Application reference number	2025/0718
-------------------------------------	-----------

Proposal Description:	The application proposes to erect a first floor extension above part of the existing ground floor extension.
Location:	43 Victoria Street, Penistone, Barnsley, S36 6EL.

Applicant	Mr Ben Taylor (BMBC)
------------------	----------------------

TITLE
Proposed Floor Plans

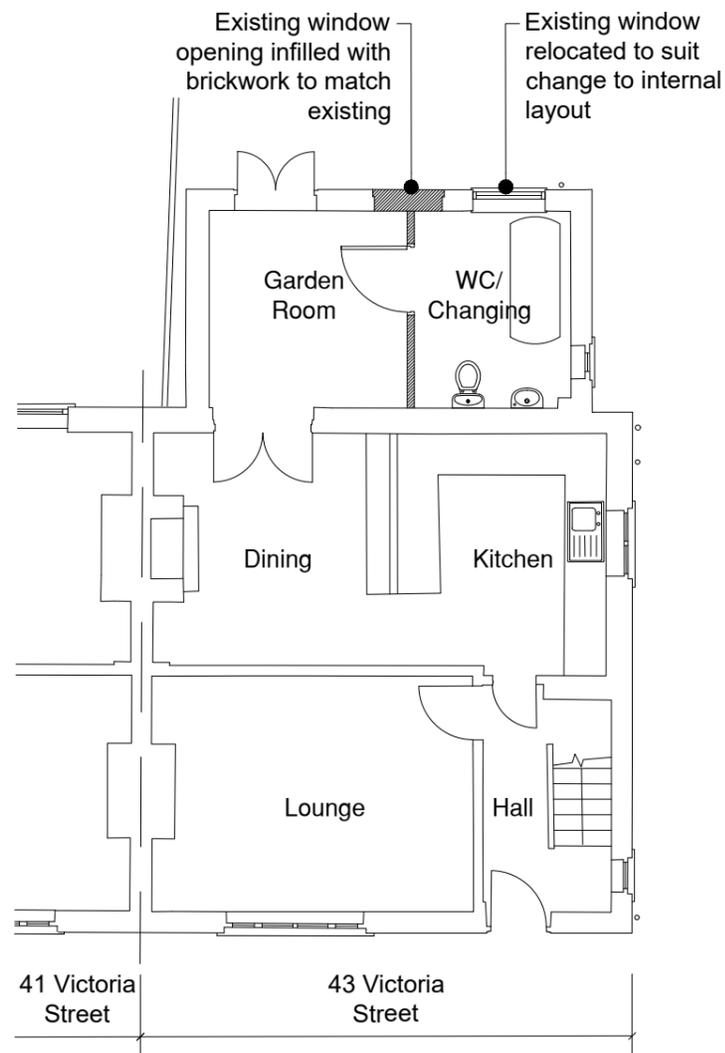
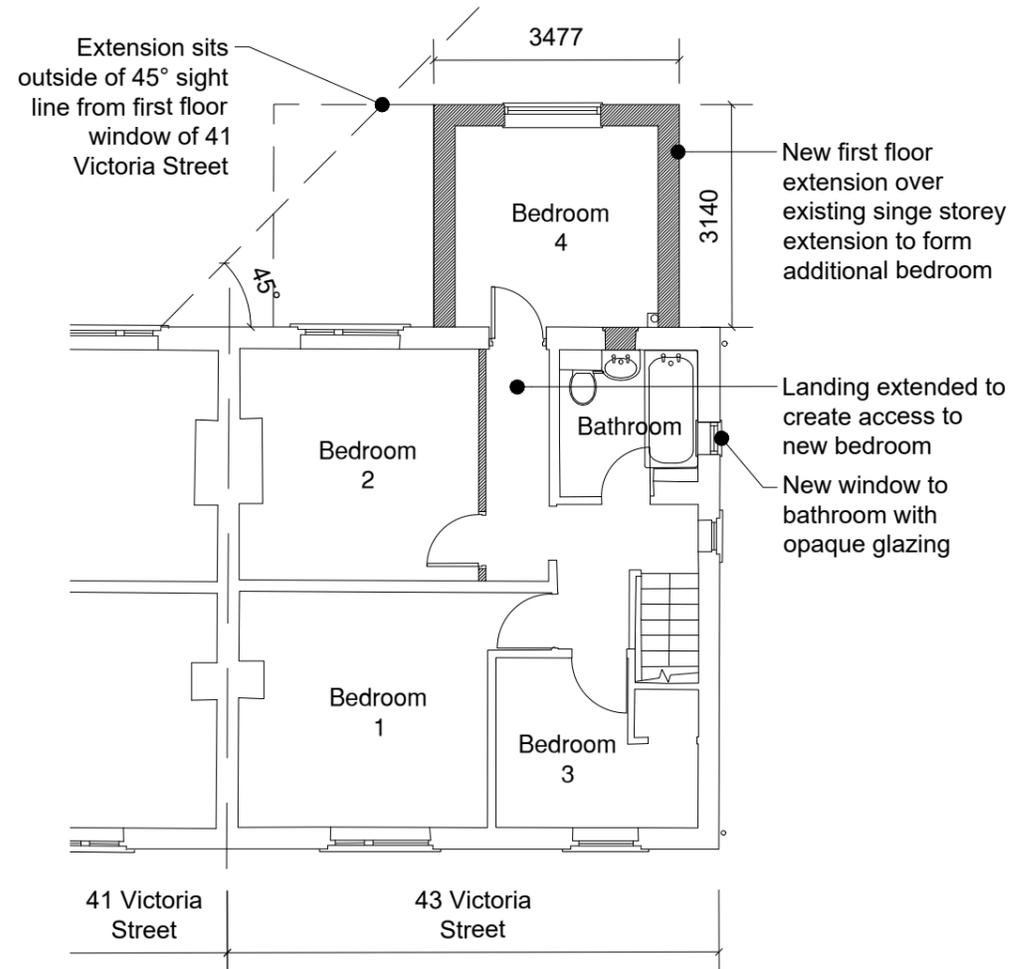
The proposed extension is essentially set in the centre of the plot, with a distance of at least 2.5m to either side boundary, given this and that the neighbouring gardens are north facing, it is unlikely that harmful overshadowing or loss of light would occur.

The proposal does not have any direct impact on highways safety or the parking provision. The proposal does create an extra bedroom and a property of 3+ bedrooms requires 2 off-street parking spaces, the application site already has provision for two off-street parking spaces and these will be retained.

TITLE  
Proposed Elevations

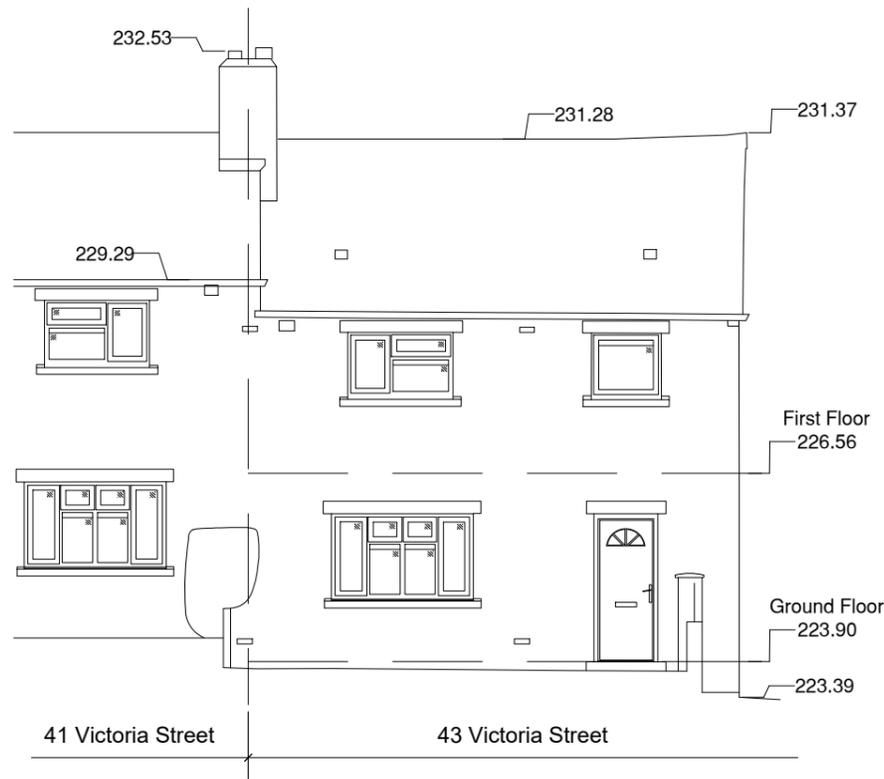
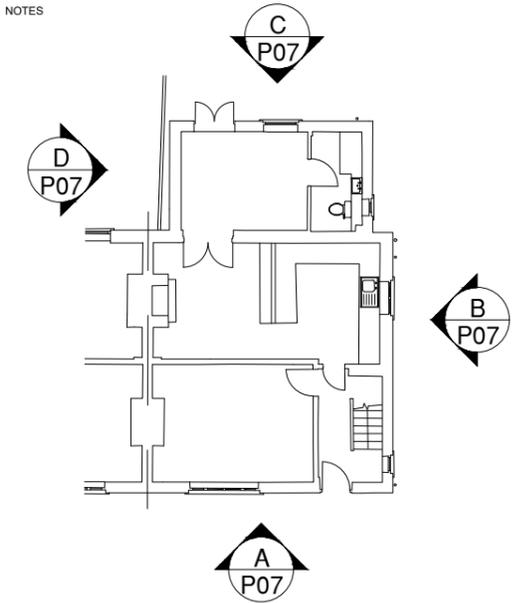
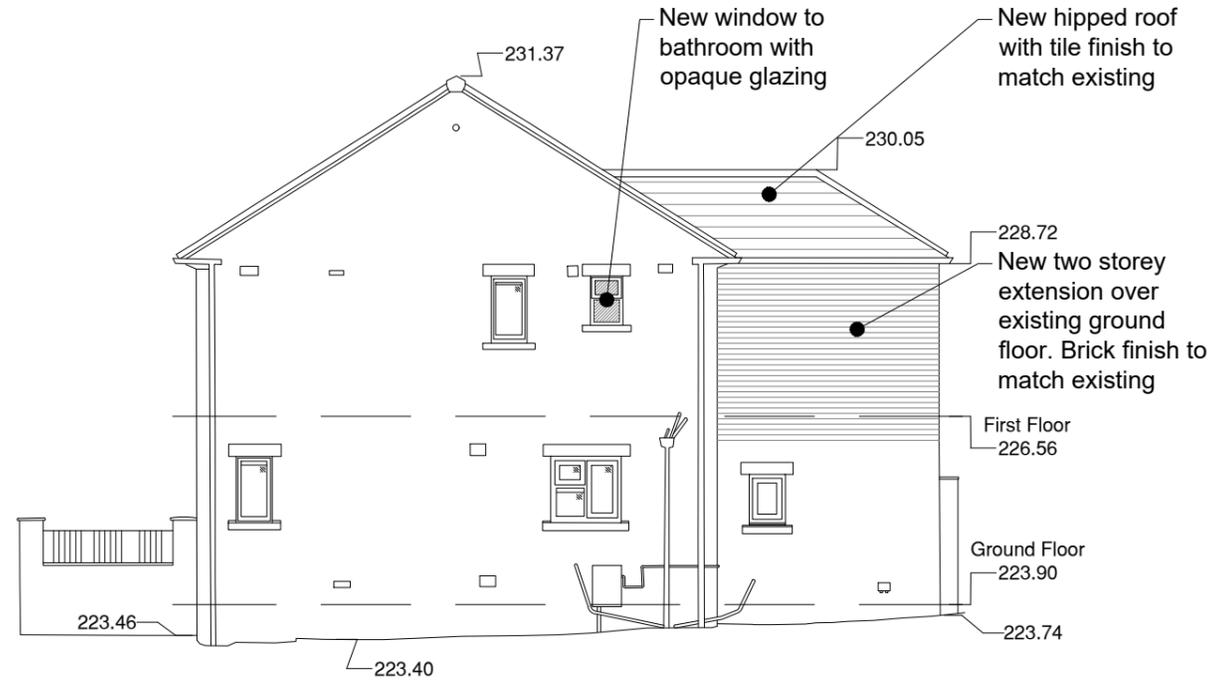
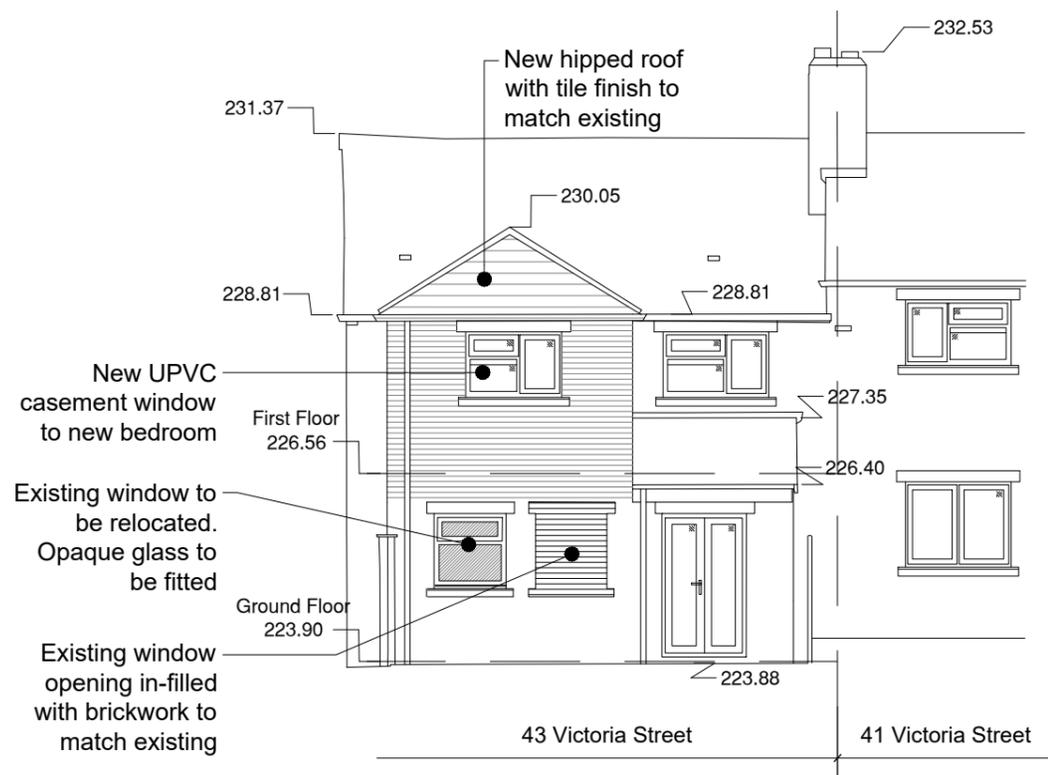
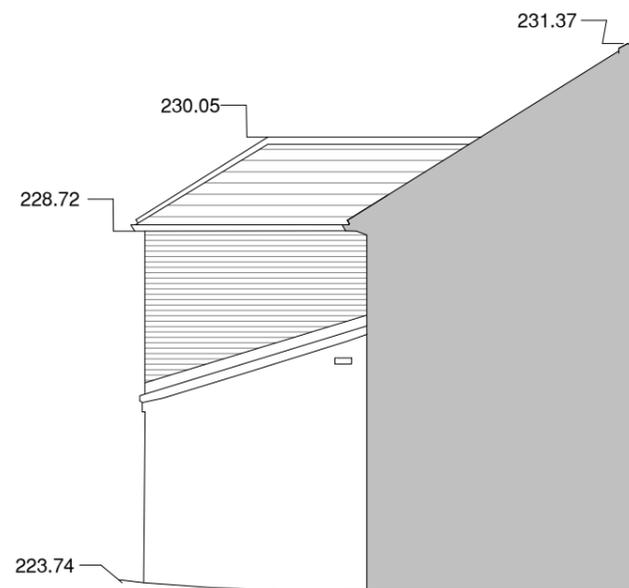
The proposed extension is to the rear of the dwelling. It projects approximately 3.1m from the rear elevation of the dwelling and will become flush with the existing rear wall of the ground floor extension. The extension does not span the full width of the property and is only 3.5m wide, set in over 2.5m from the adjoining boundary.

The proposal here, is set in from the boundary with the adjoining neighbour, enough so that there is no encroachment into the 45 degree zone. The proposed extension also has a lesser projection than 3.5m and therefore is in accordance with the guidelines set out in the SPD.

In addition to this, the roof line of the extension is set down significantly lower than the ridge of the existing house which further mitigates any overshadowing or loss of light.

The proposal introduces an additional window to the rear elevation this is set over 25m away from the property to the rear which exceeds the minimum separation distance set out in the SYRDG which requires at least 21m between habitable room windows. One new window is proposed to the ground floor rear elevation which will serve the bathroom. Another bathroom window is proposed at first floor in the existing building. This window will also be obscure

glazed as per the proposed plans and this will be secured via condition to maintain privacy and avoid overlooking.
